From: Simon Davis
Sent: 03 June 2020 19:10
To: Planning Scanning
Subject: FW: BR/83/20/PL

From: Simon Davis
Sent: 03 June 2020 19:09
To: [REDACTED]
Subject: BR/83/20/PL

Please see attached comments of WSCC Highways. Please note that you will need to:

Potential for
additional bays
on-street

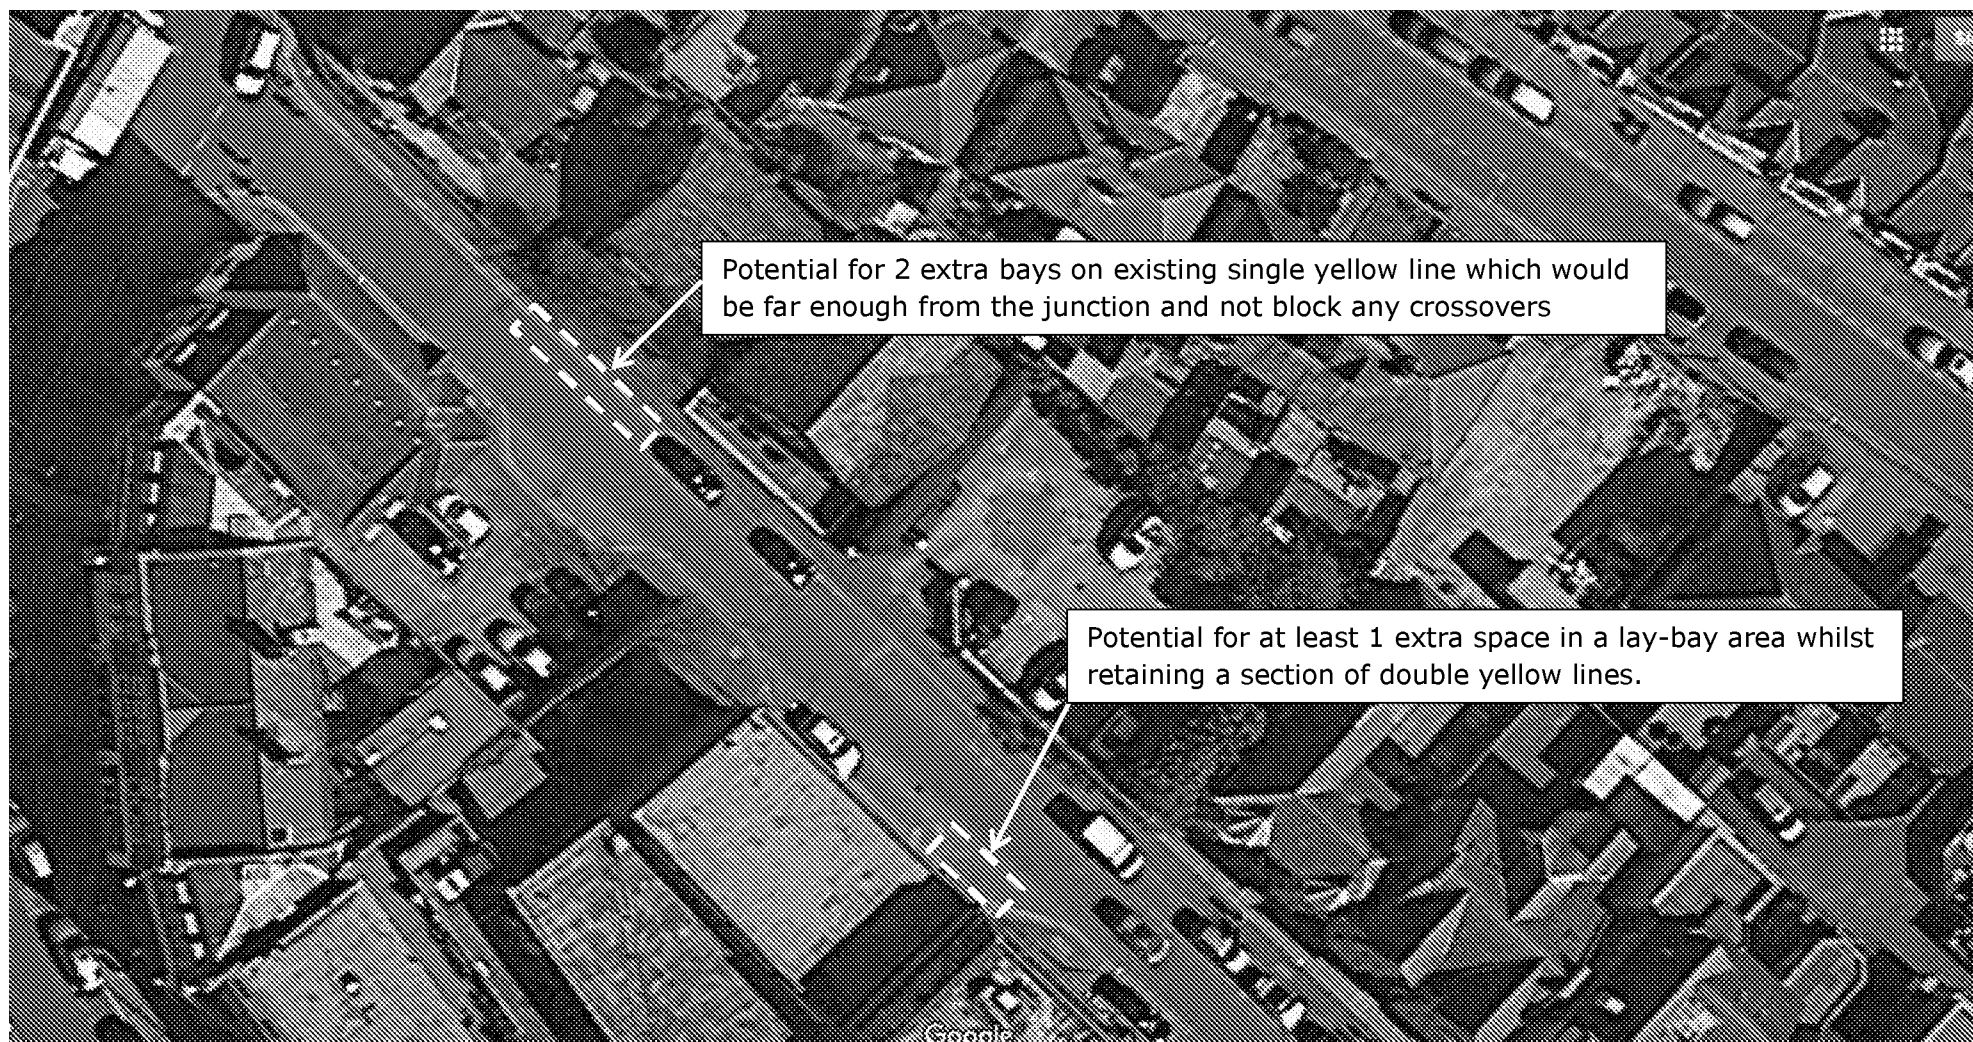
- (a) Discuss the new Permit parking bays with WSCC Parking Team Manager to set the process in motion. I'm afraid I don't have a contact but you should be able to get to the right person by ringing WSCC
- (b) Provide clarification re the suggested new parking space which is proposed outside the Recital Hall and may cause issues for vehicles wishing to enter or exit the servicing area. You need to advise on the proposed use of the serving area and the size of vehicles using this to ensure any new car parking doesn't restrict movements in and out. We will then need to reconsult with Highways to check this.
